CITY OF ALBUQUERQUE

March 10, 2022

**Re: Commissary Kitchen
1411 South 4th St SW
Traffic Circulation Layout
Engineer's Stamp 03-01-2022 (L14-D063)**

A1 SITE PAVING PLAN
1" = 20'-0"

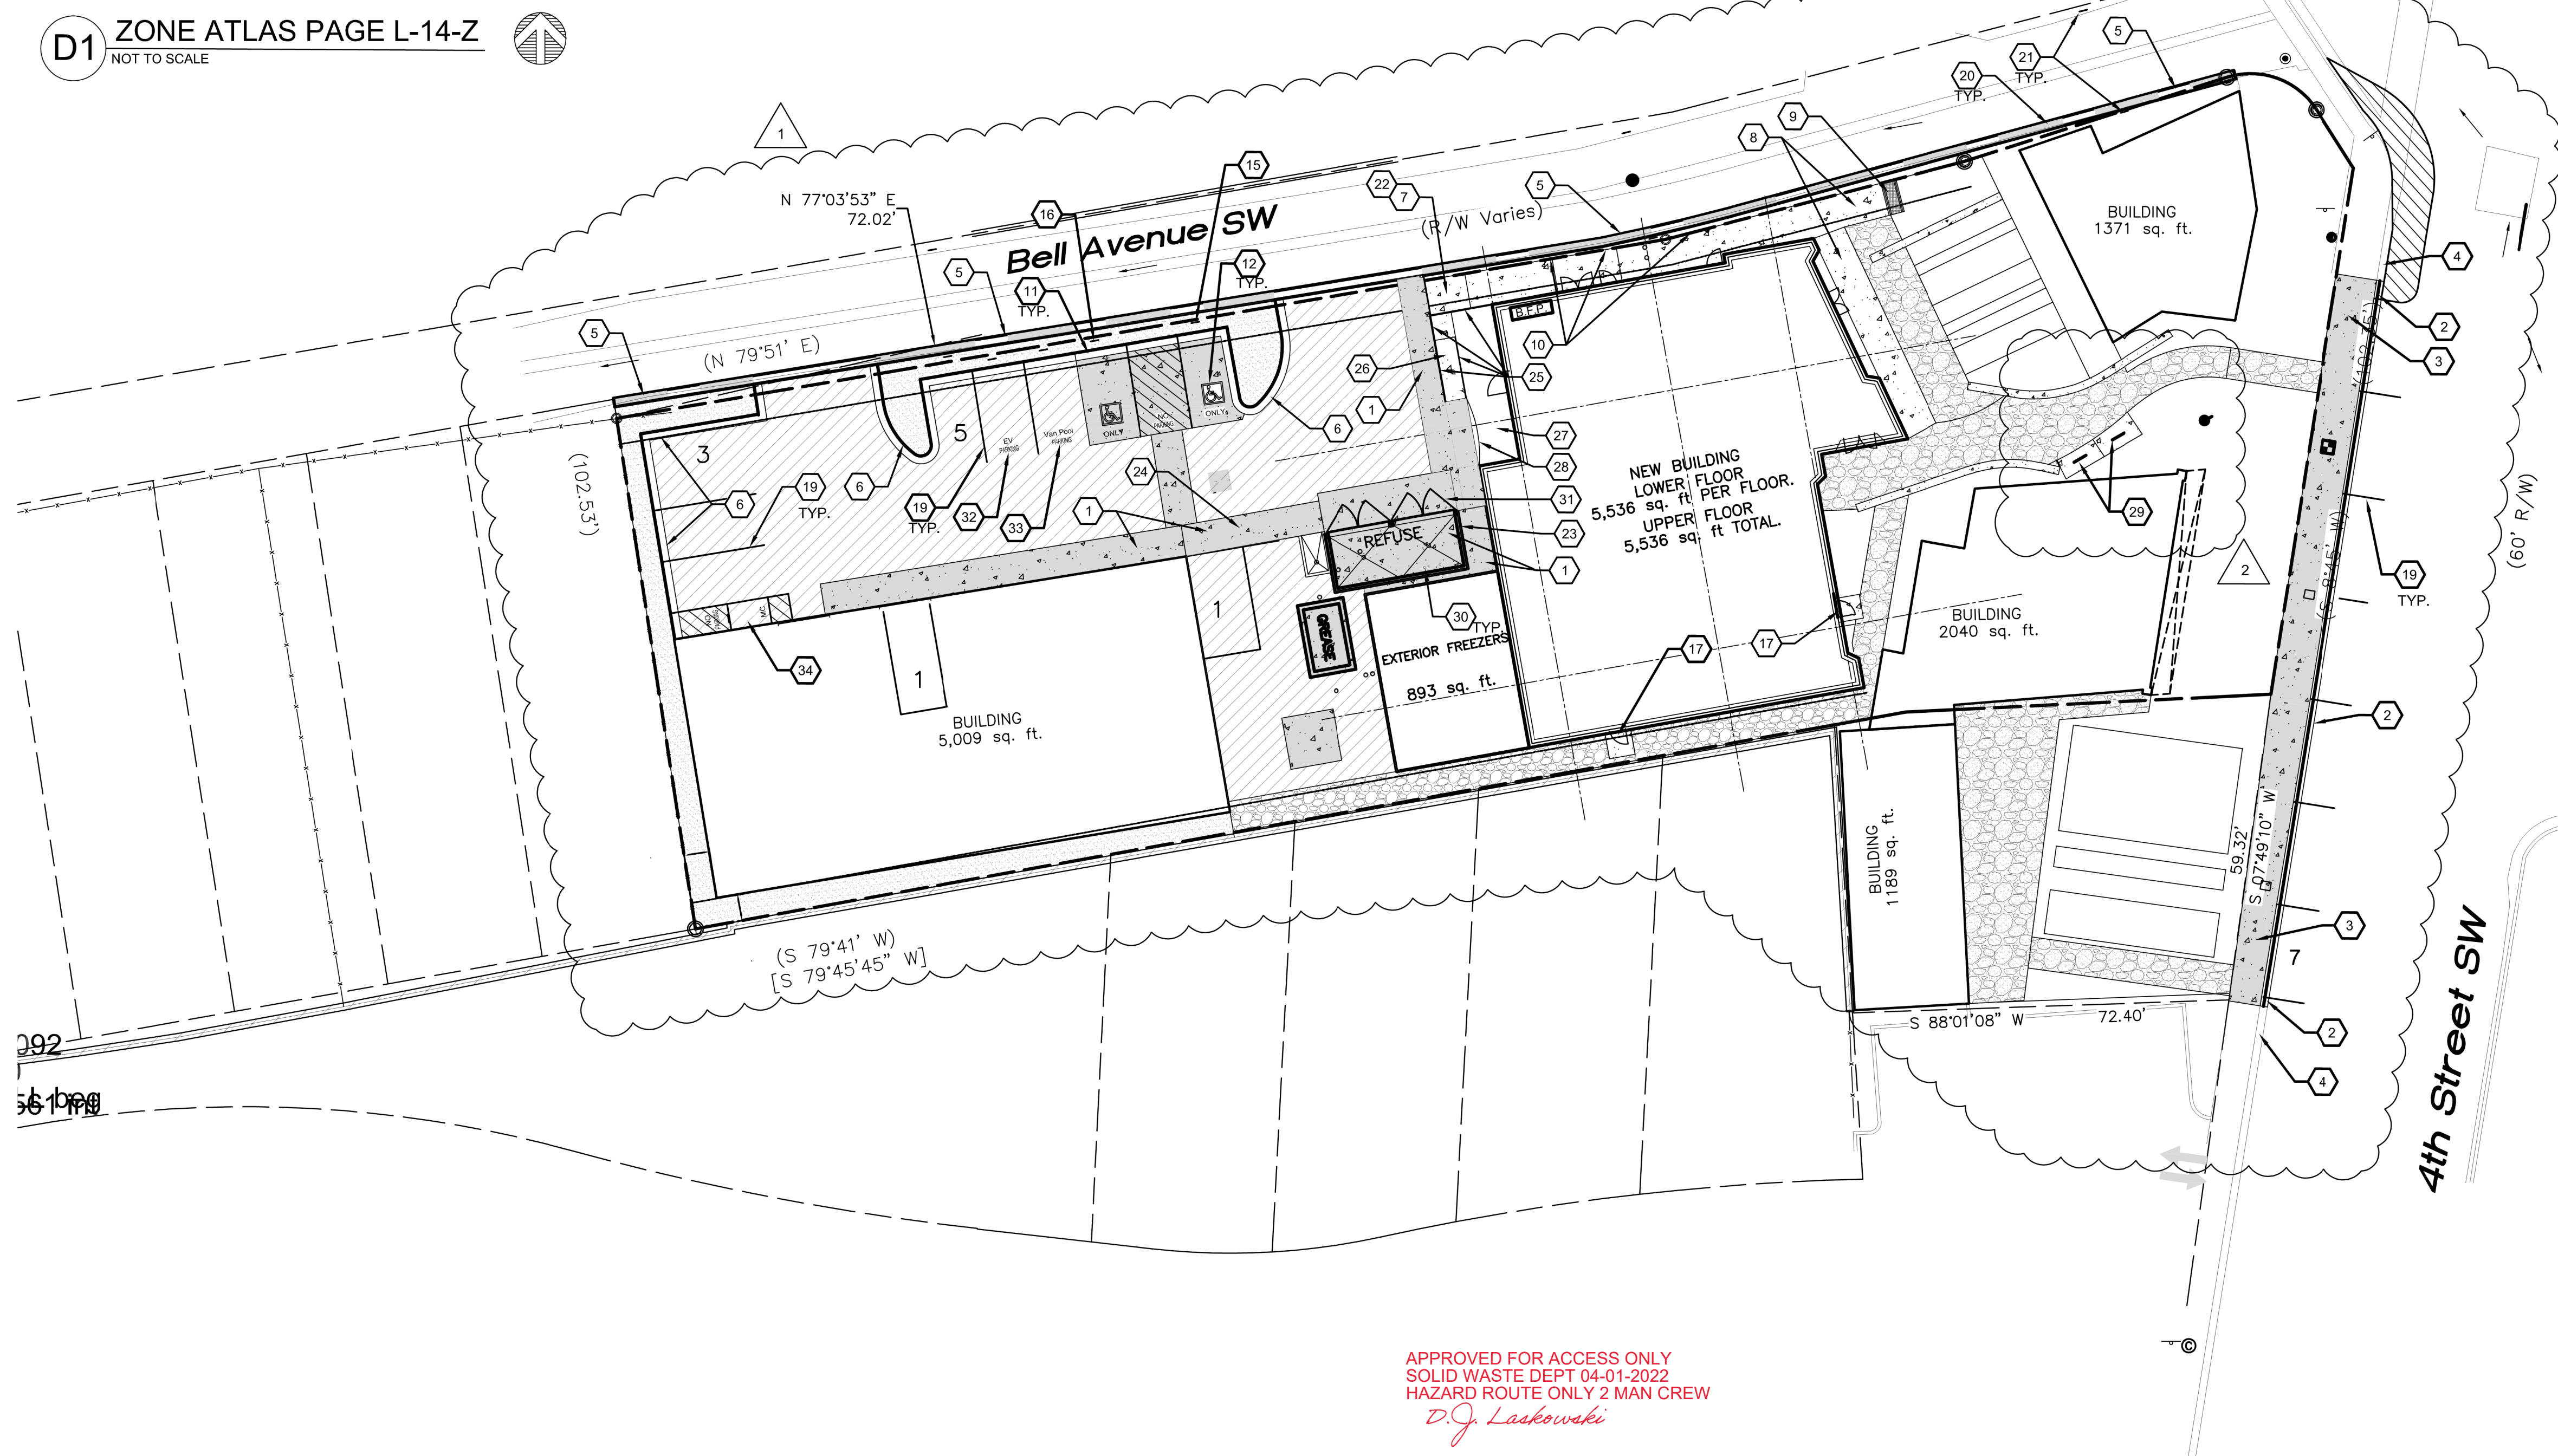
1. NO parking stall will back into 4th Street. This will not be allowed. Please modified you parking stall design off 4th Street (**classified as Minor Arterial**).

2. 4th/Barelas: What is the status for an ADA ramp at this corner? You will need to provide a current/update ADA ramp.
3. What is the status for sidewalk off 4th St, Barelas St and Bell? You will need to provide sidewalk or obtain a sidewalk variance from Jeanne Wolfenbarger (505-924-3991)

4. **All proposed signage and pavement markings:** A detail of sign face and any type of pavement markings.
5. **Keyed Notes:** All keyed notes references to sheet 502, you will need to provide this sheet as part of 7your submittal.

6. **Keyed Notes 29/30:** Paint bollards yellow-Add note.
7. **Bell Ave.(Proposed entrance):**
 - Provide entrance design (2)
 - Entrance width needs to be provided.

8. All proposed parking stalls: Dimensions will need to be shown on site plan
9. Listed are the number of parking spaces required by the IDO as well as the proposed number of parking spaces including **bicycle and motorcycle parking**. Coordinate/discuss with Zoning.

11. Please list the width and length for all existing, proposed parking space and drive aisle. Some dimensions are not shown.

13. The ADA accessible spaces must include an access aisle. Van accessible aisles should be 8ft wide; all others should be 5ft wide.
14. The ADA accessible parking sign must have the required language per 66-7-352.4C NMSA 1978 **"Violators Are Subject to a Fine and/or Towing."** Please call out detail and location of signs.

21. Show all drive aisle widths and radii. Some dimensions are not shown.
22. The minimum drive aisle dimensions are shown below

A1 SITE UTILITY PLAN
1" = 20'-0"

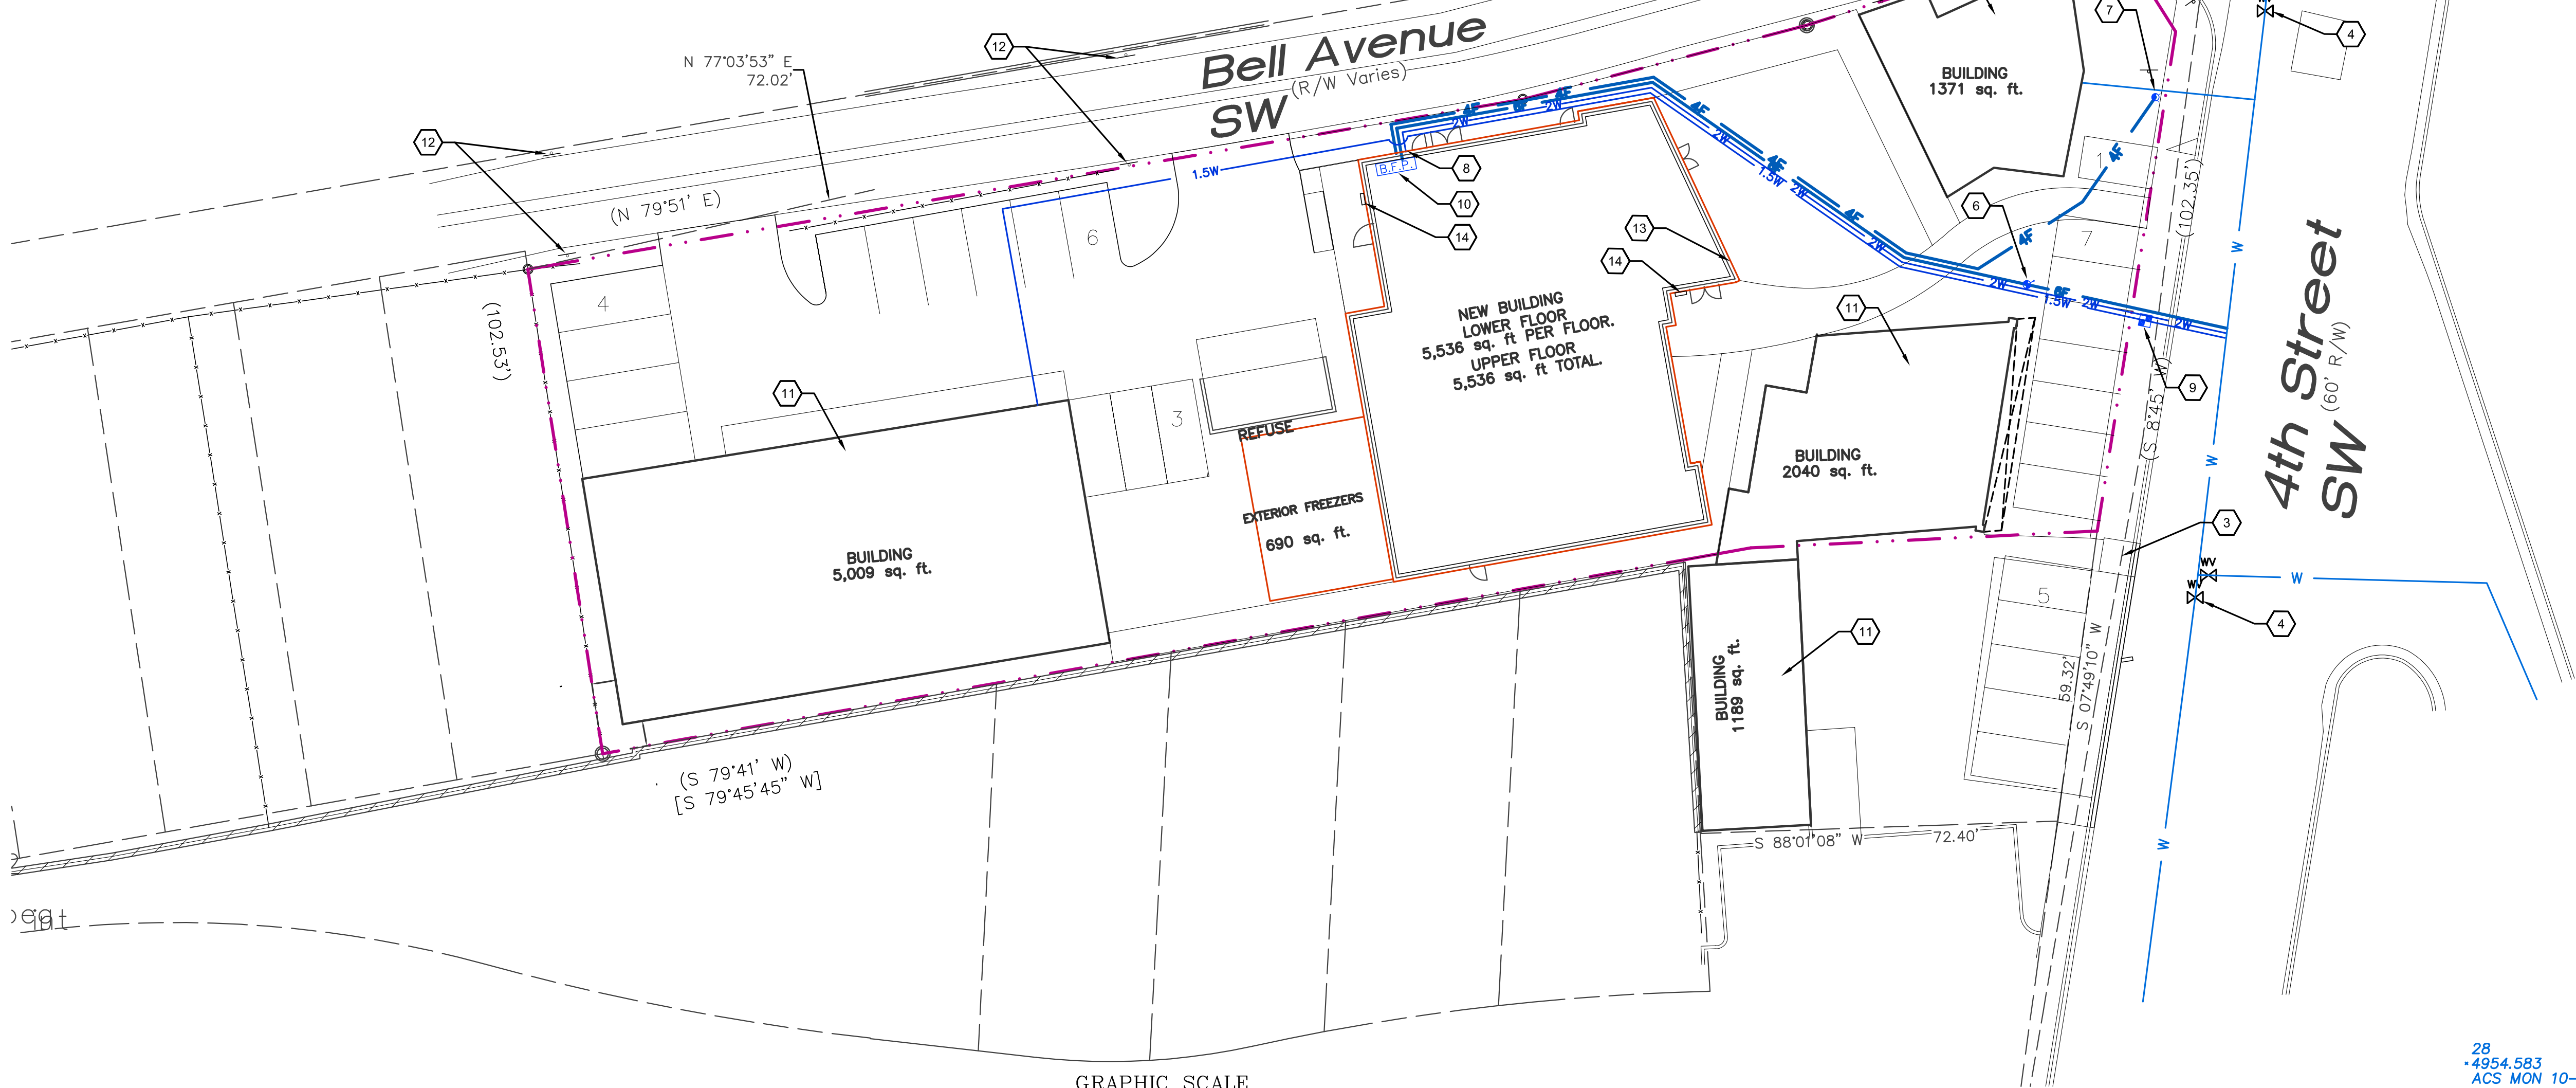
27. All sidewalks along streets should be placed at the property line.
28. .
29. Provide a copy of refuse approval.
30. Fire Department: An approval Fire 1 plan needs to be provided.
